KITTITAS COUNTY

DEPARTMENT OF PUBLIC WORKS

MEMORANDUM

TO: All Staff
FROM: Public Works Plan Review Team
DATE: March 3, 2025
SUBJECT: AU-25-00004 Wetzel

Kevin & Laurel
Wetzel
Parcel # 799436
330 Cattail Rd.
Ellensburg, WA 98926

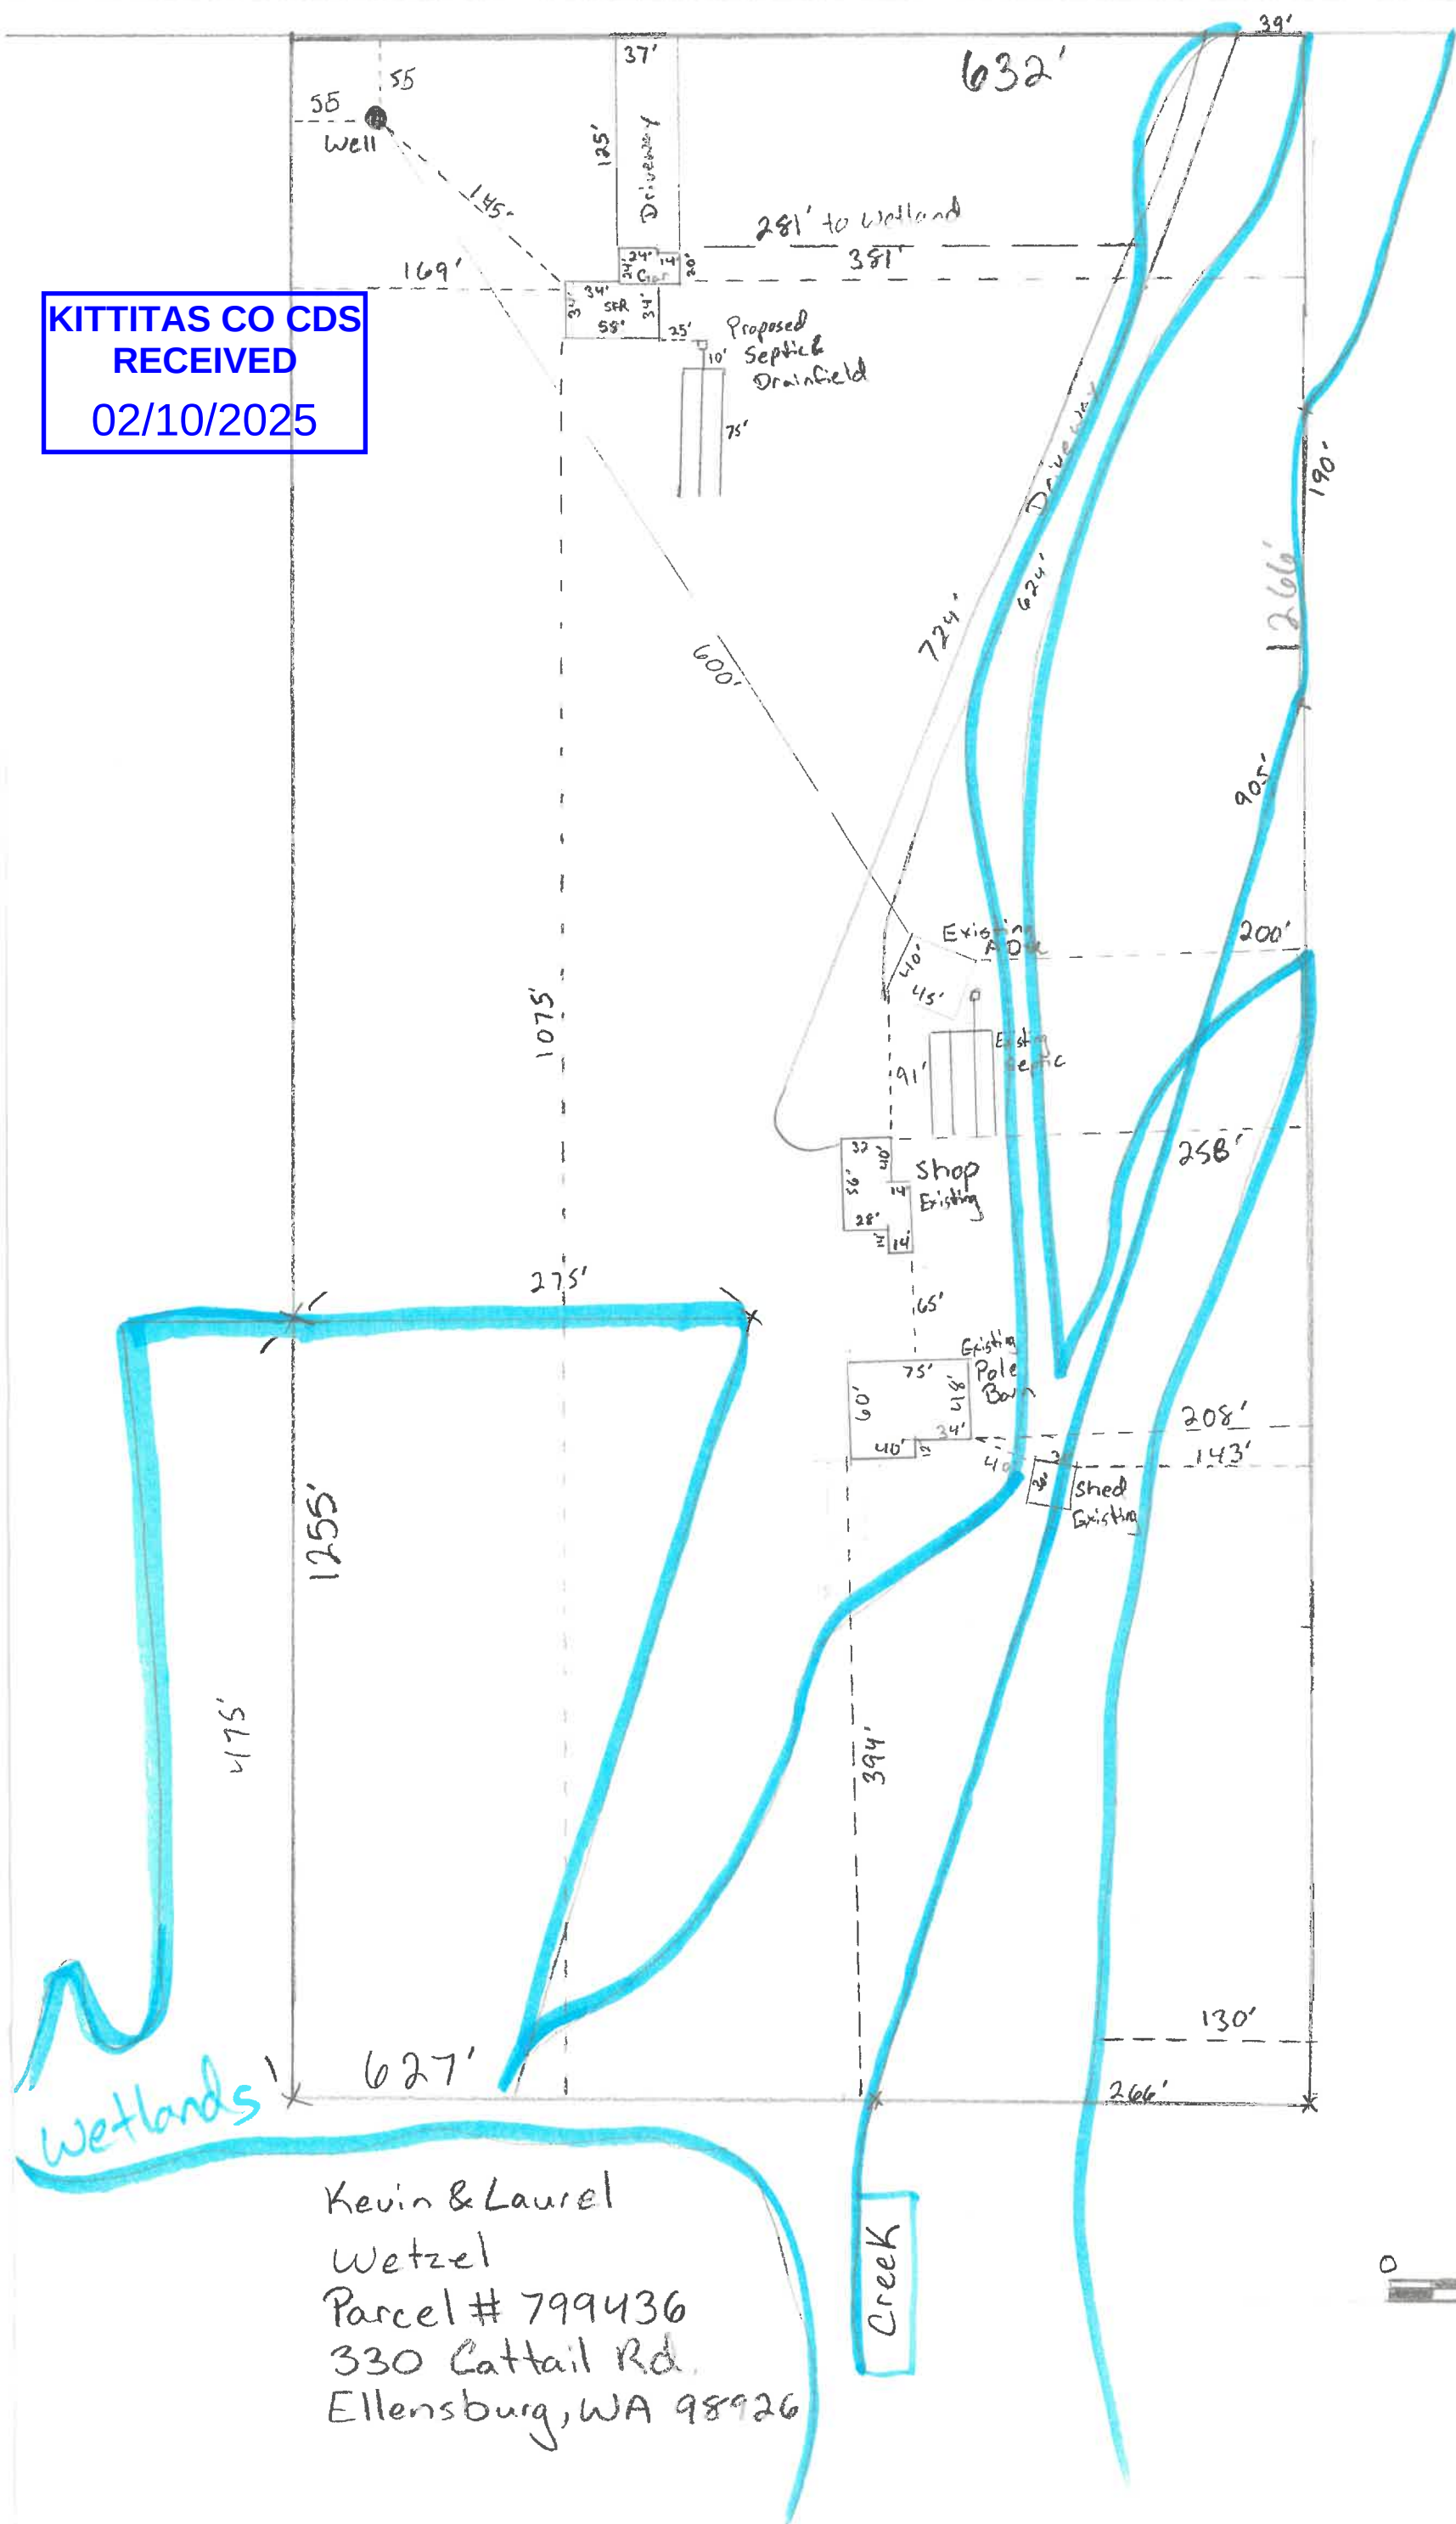
ACCESS	<ol style="list-style-type: none">1. An approved access permit shall be required from the Kittitas County Department of Public Works prior to creating any new driveway access or altering an existing access.2. Access spacing requirements on Cattail Road are 100 feet for accesses on the same side of the road as proposed access.3. Maintenance of driveway approaches shall be the responsibility of the owner whose property they serve. The County will not maintain accesses.4. Any further subdivision or lots to be served by proposed access may result in further access requirements. See Kittitas County Road Standards.5. In addition to the above-mentioned conditions, all applicable Kittitas County Road Standards apply to this proposal. Access is not guaranteed to any existing or created parcel on this application.
ENGINEERING	Except as exempted in KCC 14.05.060, no grading or filling upon a site involving more than one hundred (100) cubic yards shall be performed without a grading permit from the County Engineer or Public Works designee (KCC 14.05.050). An application for grading in excess of five hundred (500) cubic yards shall be accompanied by an engineered grading plan (KCC 14.05.080). (CP)
